DARLINGTON PUBLIC SCHOOL
 SSD - 9914 ARCHITECTURAL DESIGN UPDATE

RESPONSE TO GANSW

GOLDEN GROVE STREET, DARLINGTON, SYDNEY
 Department of Education

fjmt studio architecture interiors urban landscape
 28 SEPTEMBER 2020 REV 01

title
Perspective Sections - Facade Eastern Facade - FT04, 05, 08

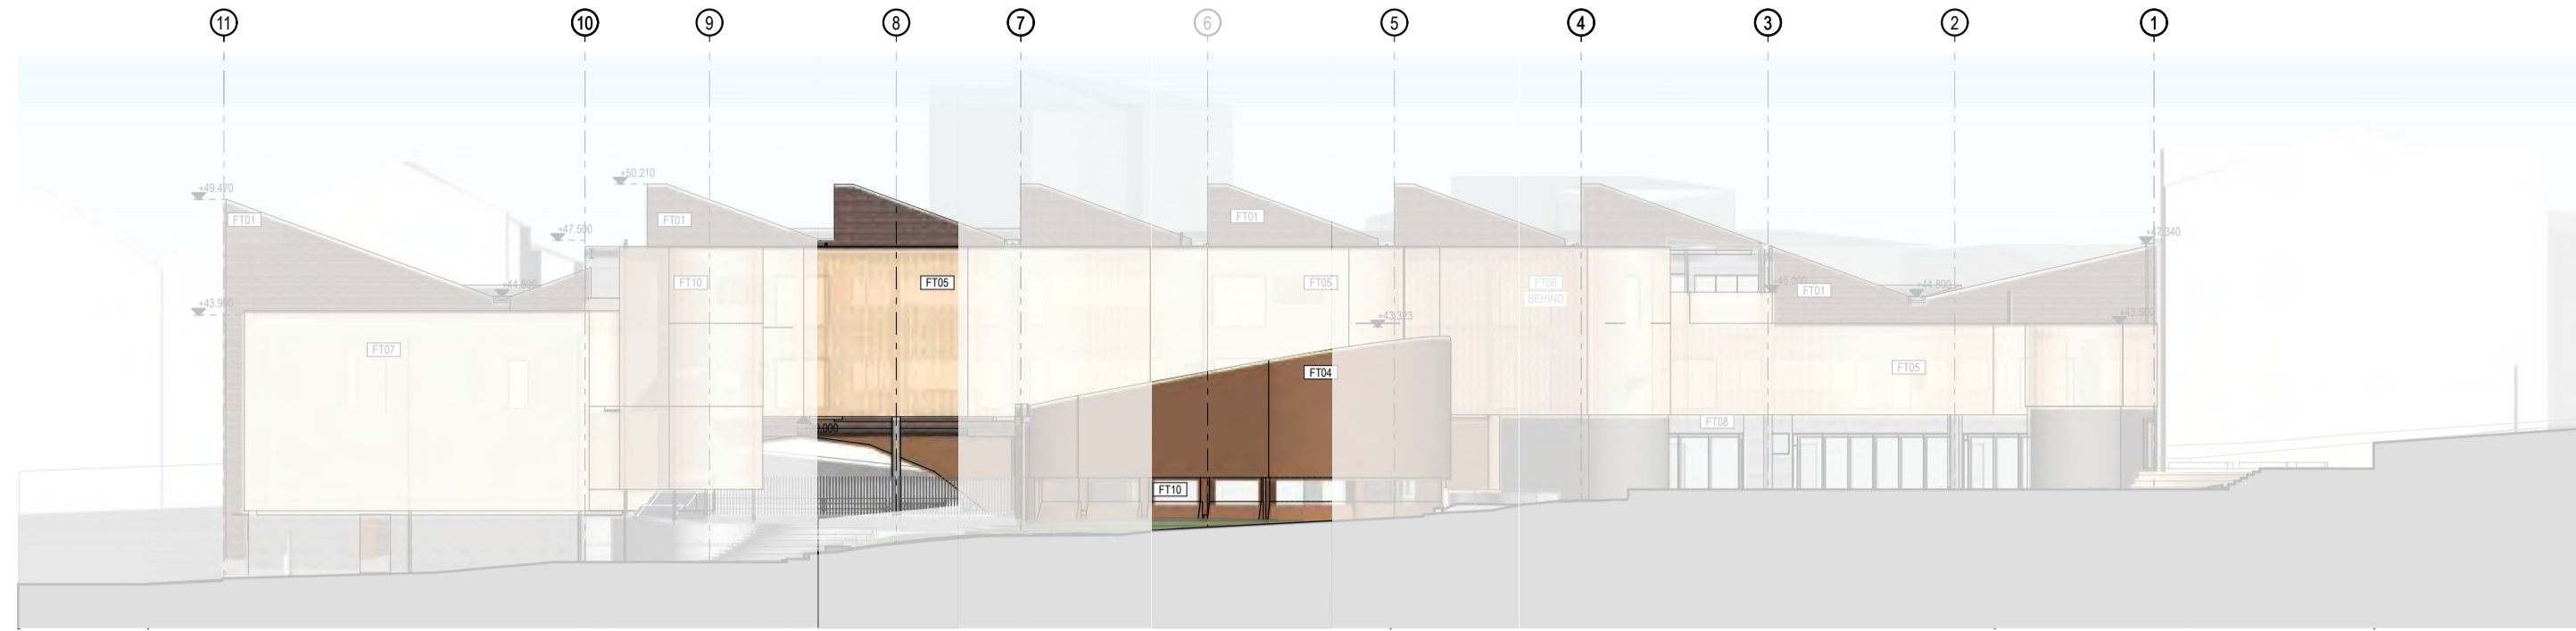
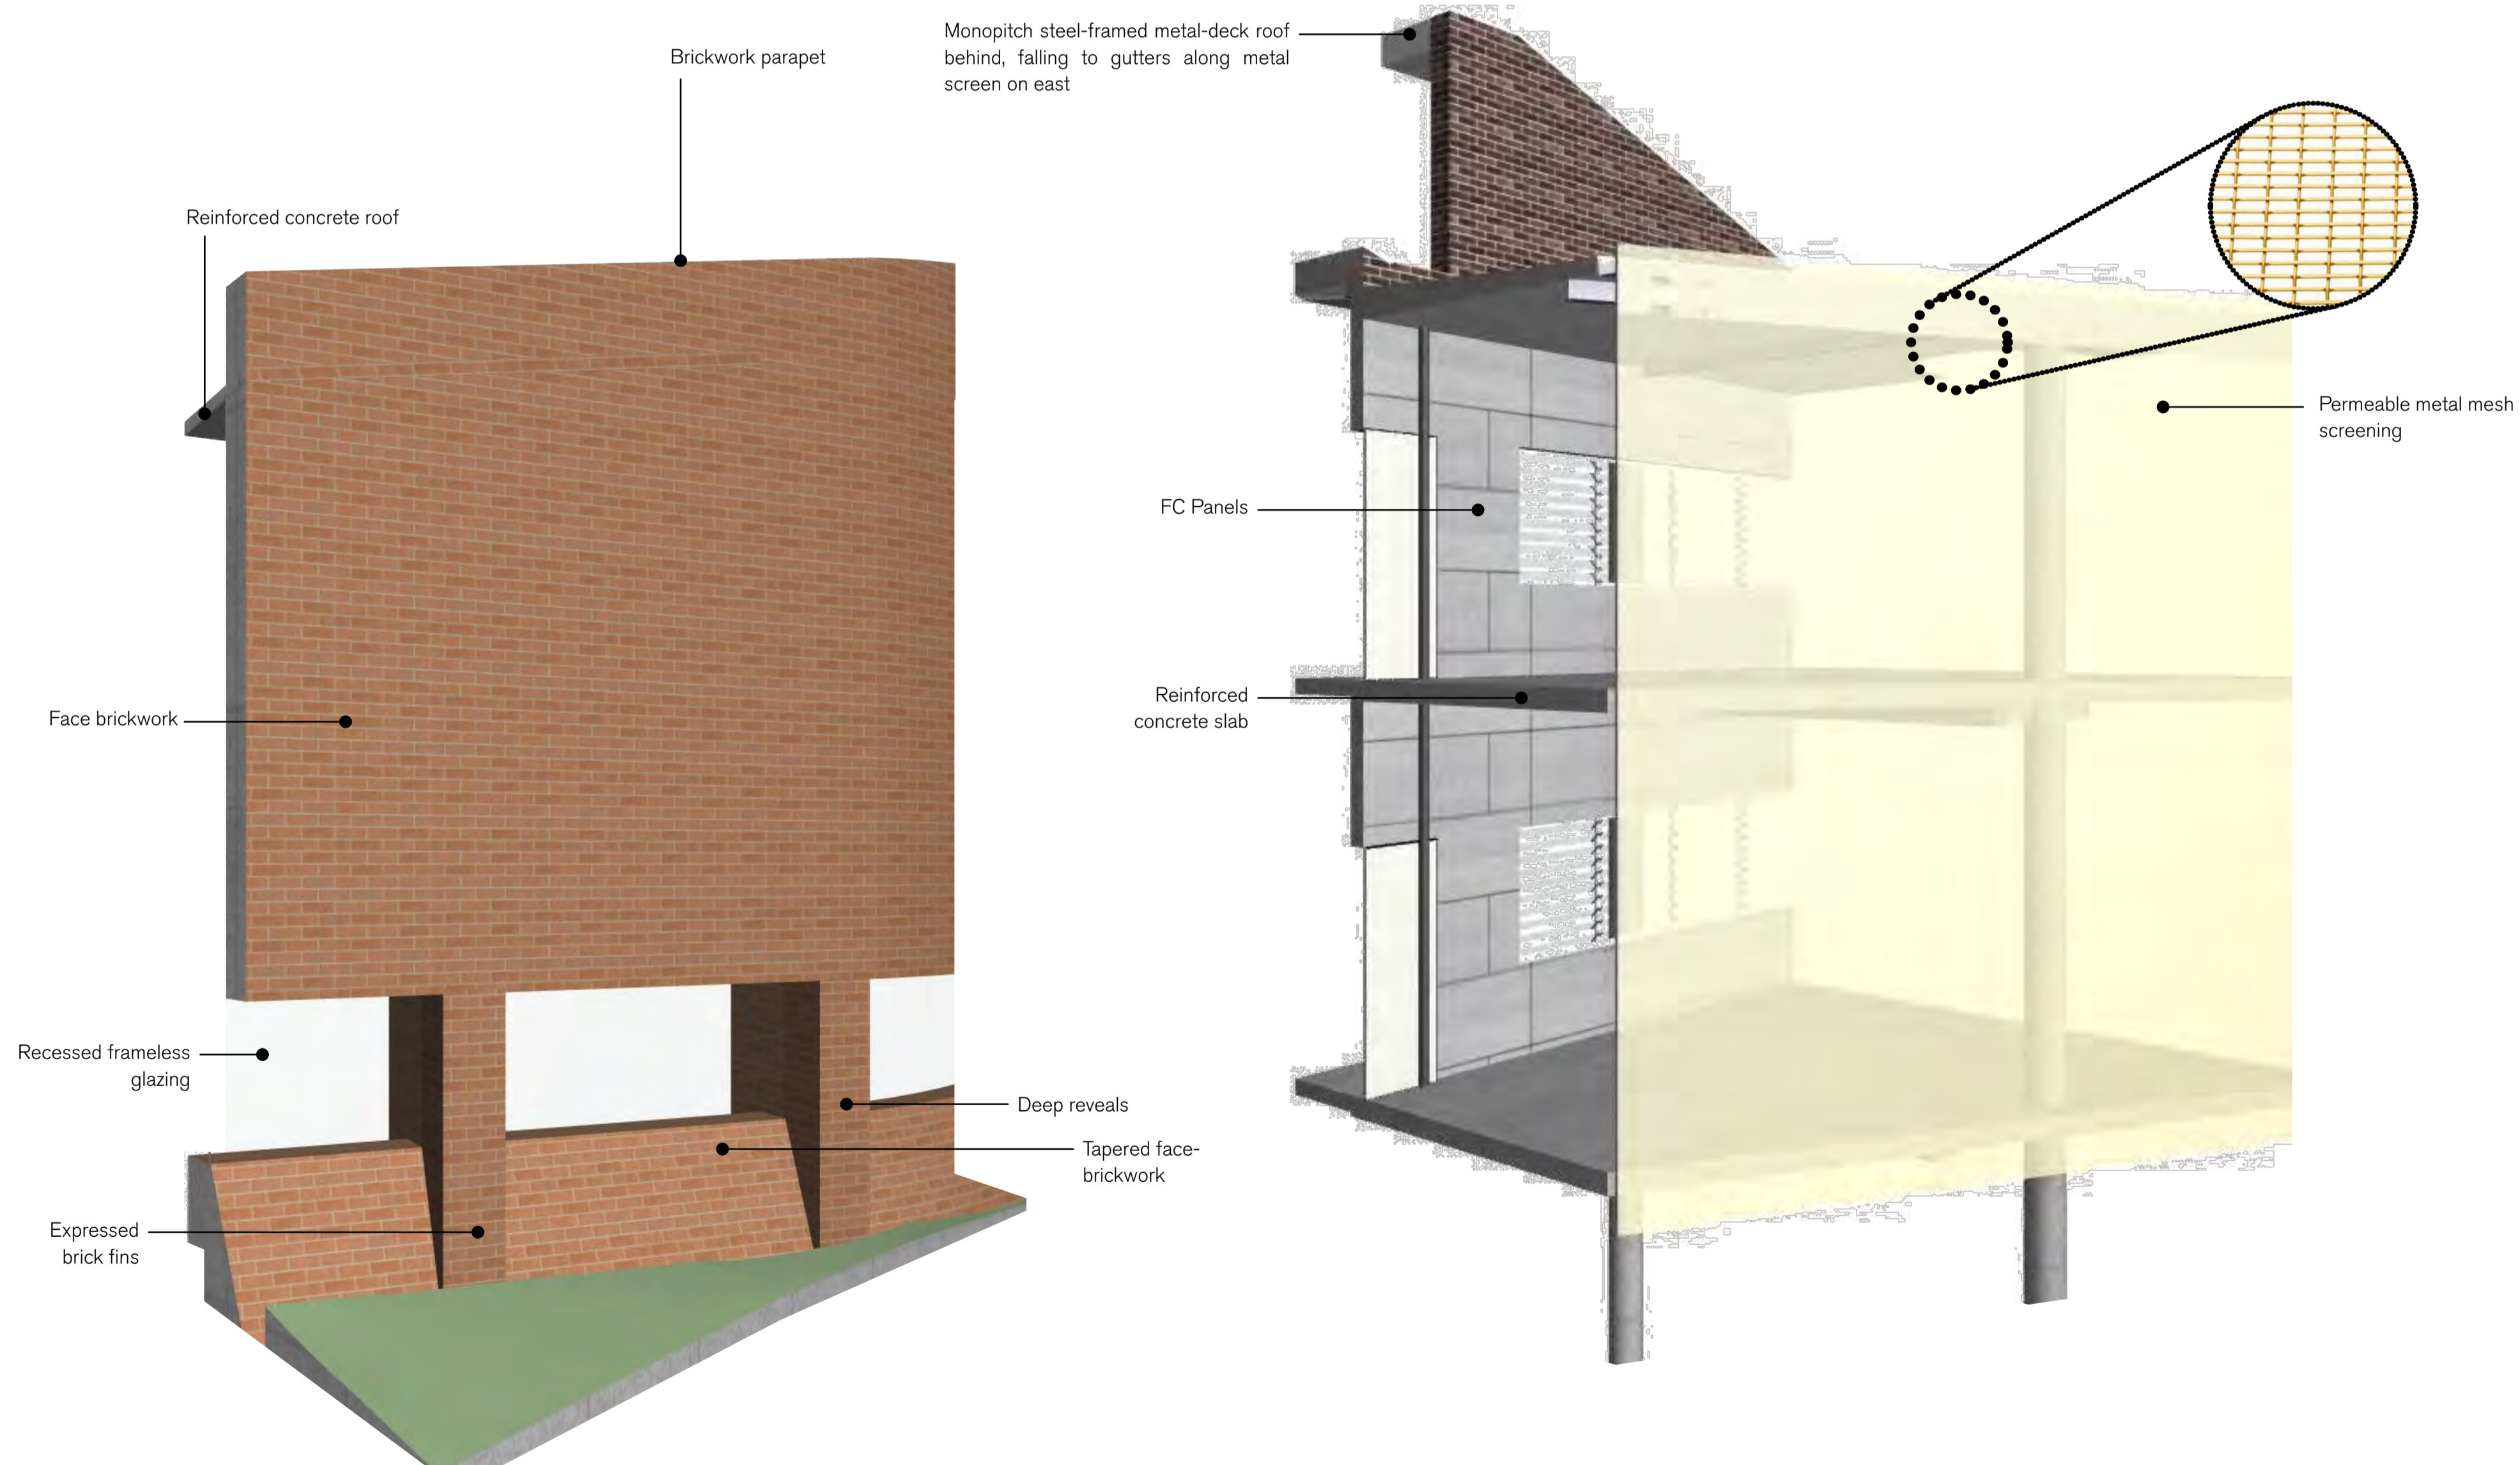
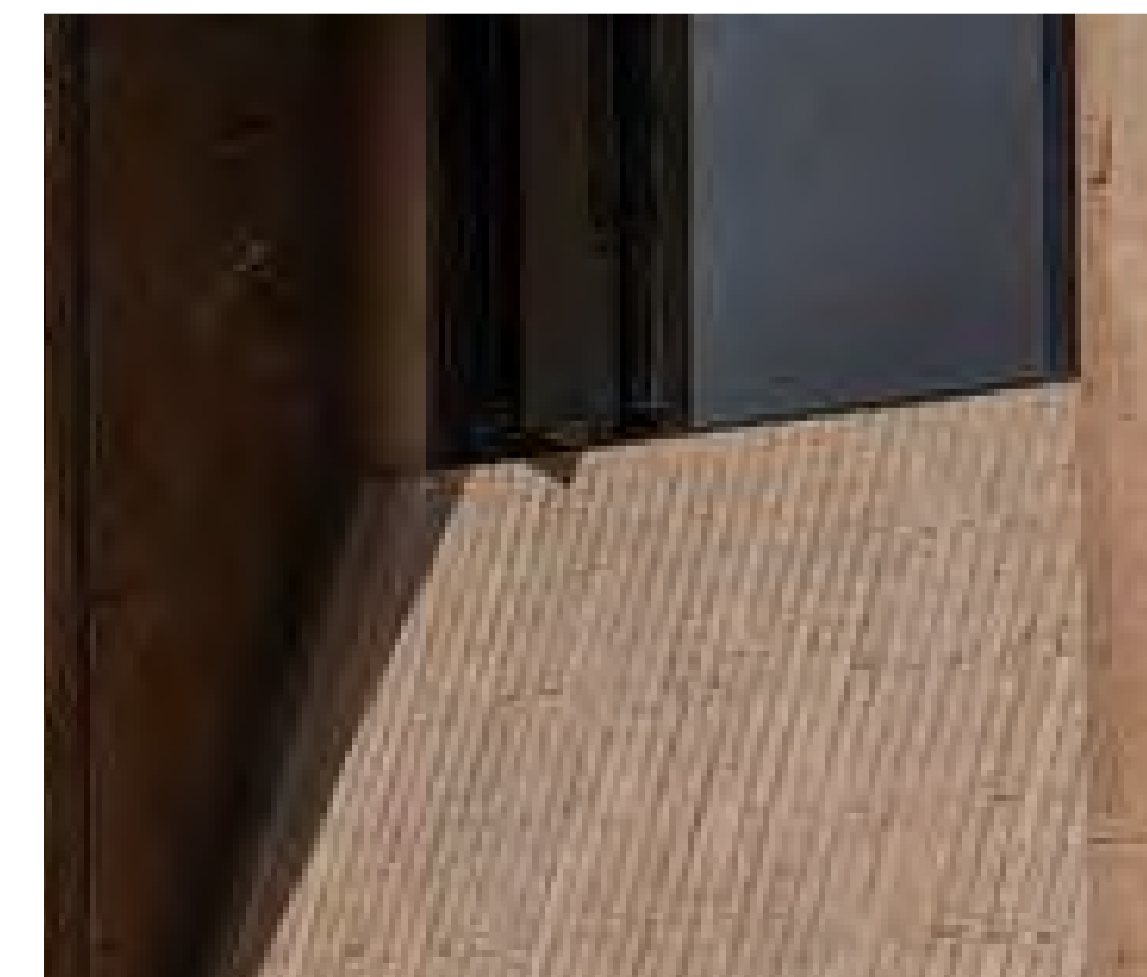
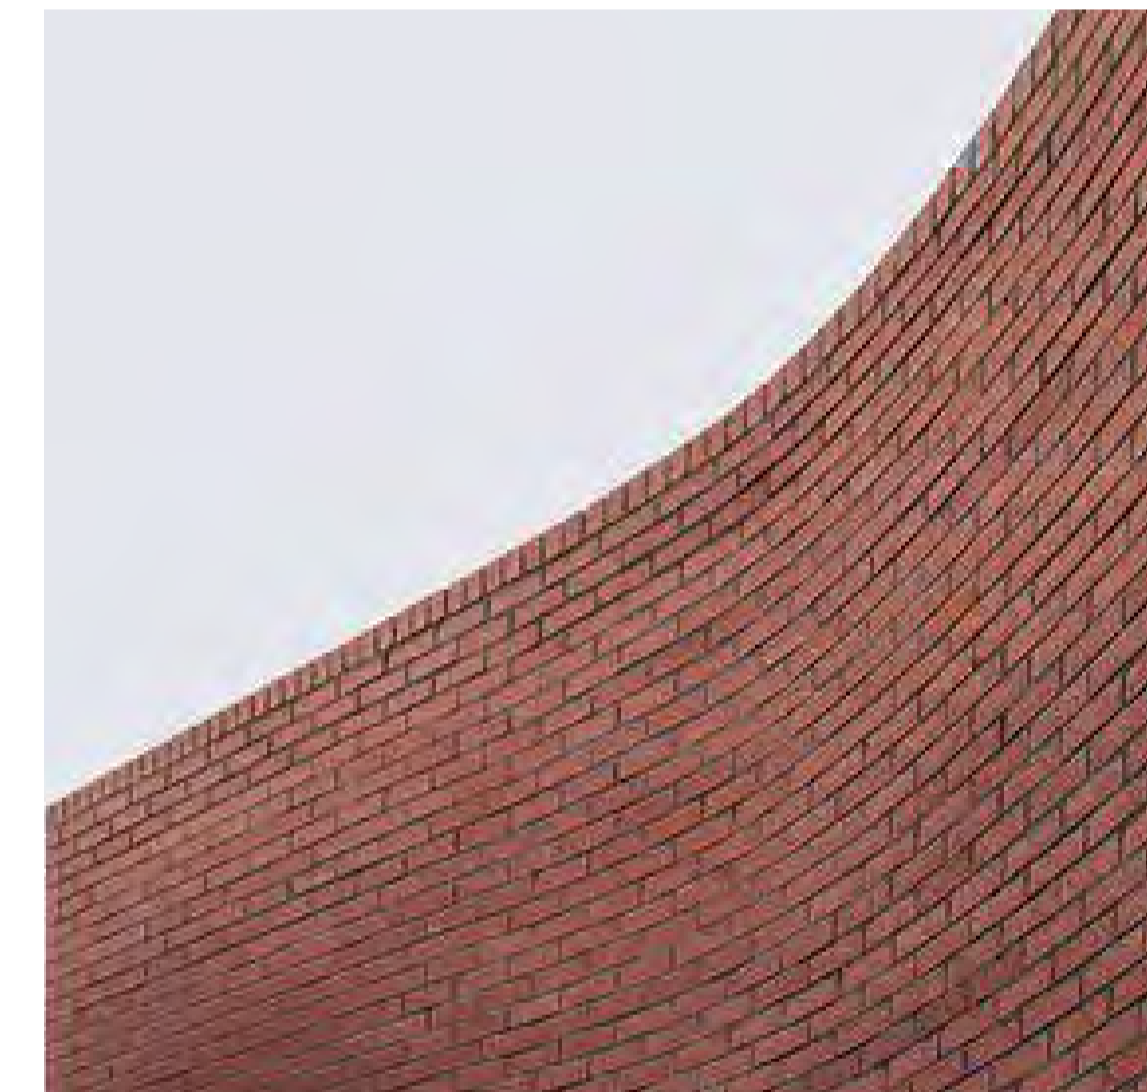
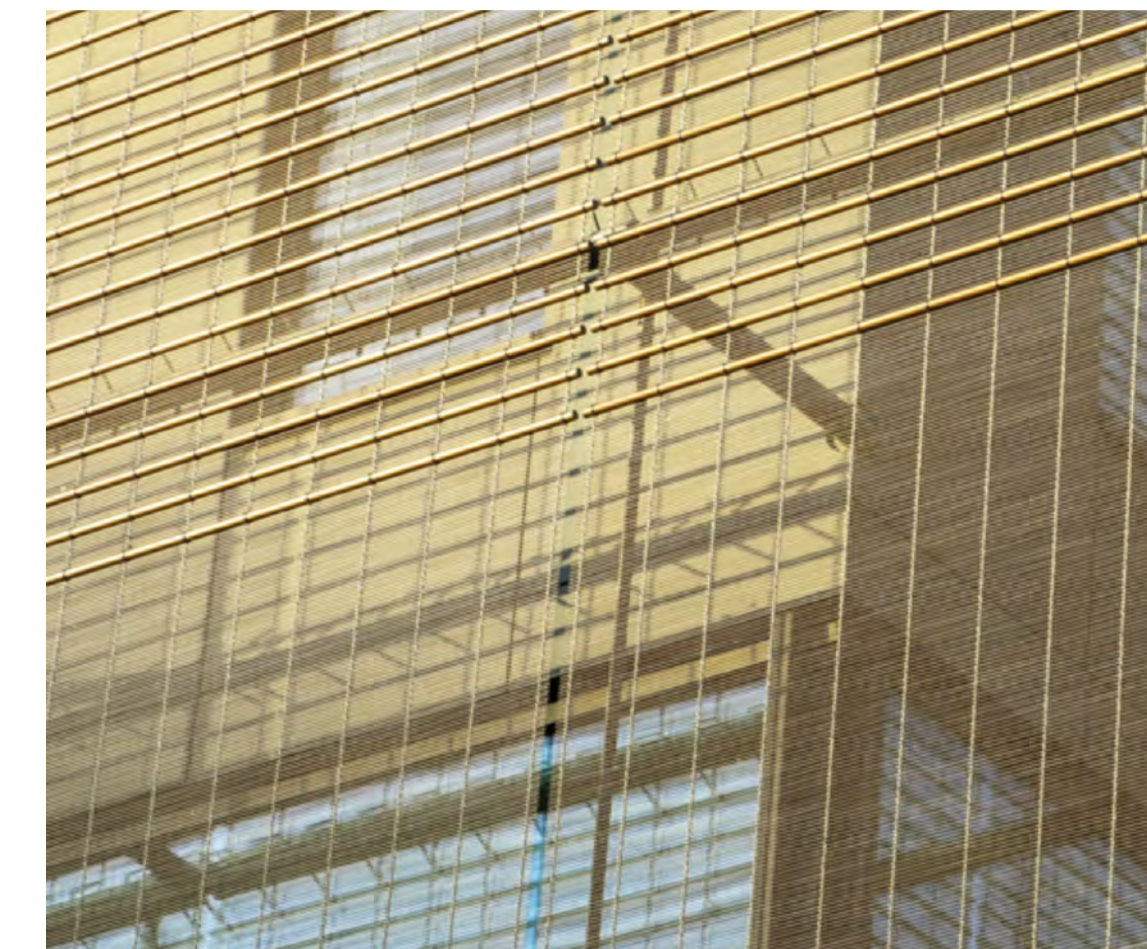
Item	Government Architect Initial Response to SSDA, 09 July 2020	fjmt Response	Page
1	The proposed buildings present large blank facades to both Golden Grove and Abercrombie streets. Articulation of the facades, further definition of openings and detailing of materials to positively address the public domain is requested.	<p>The facades facing Abercrombie Street have been further developed and articulation to the western and southern facades has been incorporated.</p> <p>The glazing and brickwork to the southern facade of the hall building has been detailed to provide a finer grain response to the streetscape.</p> <p>The previous single large window into the south facade of the communal hall has been divided into 5 smaller windows. These are set into a recessed brick facade with large splayed sills and clearly defined brick blades between the glazing elements.</p> <p>This creates a more interesting street frontage, responding to the local context and a more structurally efficient result.</p> <p>The openings along the low-level brick facade facing Golden Grove street have also been refined.</p>	Refer Section 1.0, pages 5-10.

title
Landscape Plans
Landscape Ground Plane Plan

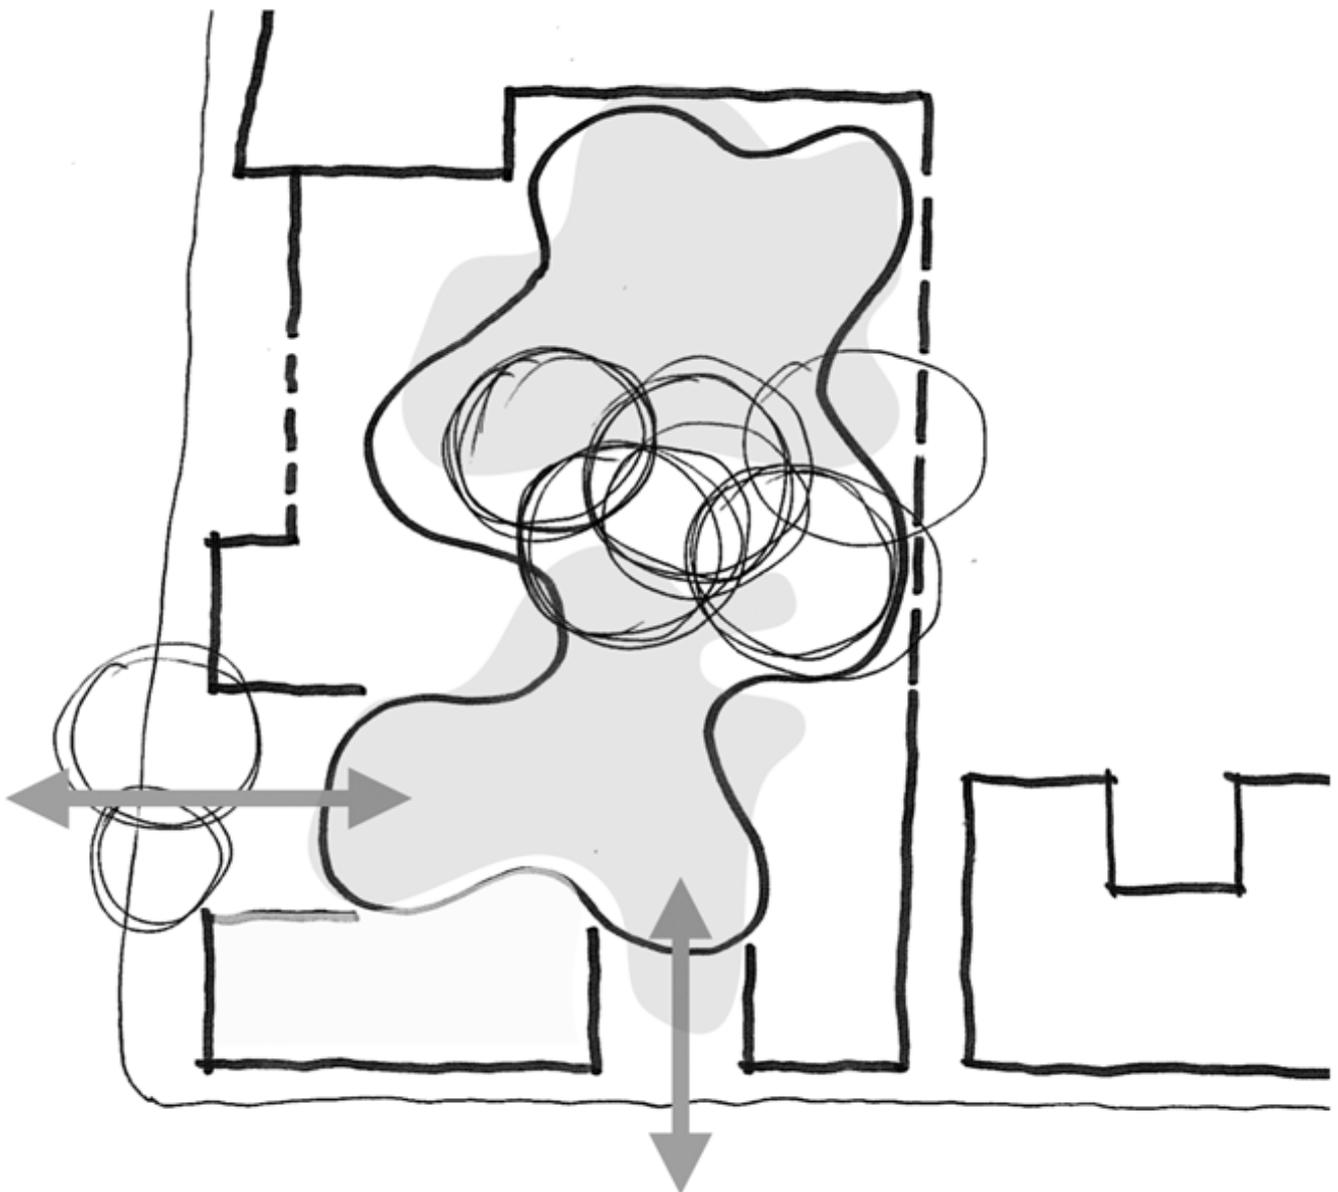
3	The previously included landscaped setback along Golden Grove street has been deleted, and the building no longer engages with the public domain in a positive manner nor does it contribute to public amenity. Articulation of this street edge and the inclusion of public amenity is requested.	<p>The Golden Grove facade is set back from the western boundary line by 2 meters. Landscaping at grade is proposed in this zone, including a feature tree near the south-western corner.</p> <p>The secondary entrance and fence line on Abercrombie Street has been set back 3 meters and incorporates a generous landscaped zone alongside the public footpath.</p>	Refer Section 3.0, pages 14-15
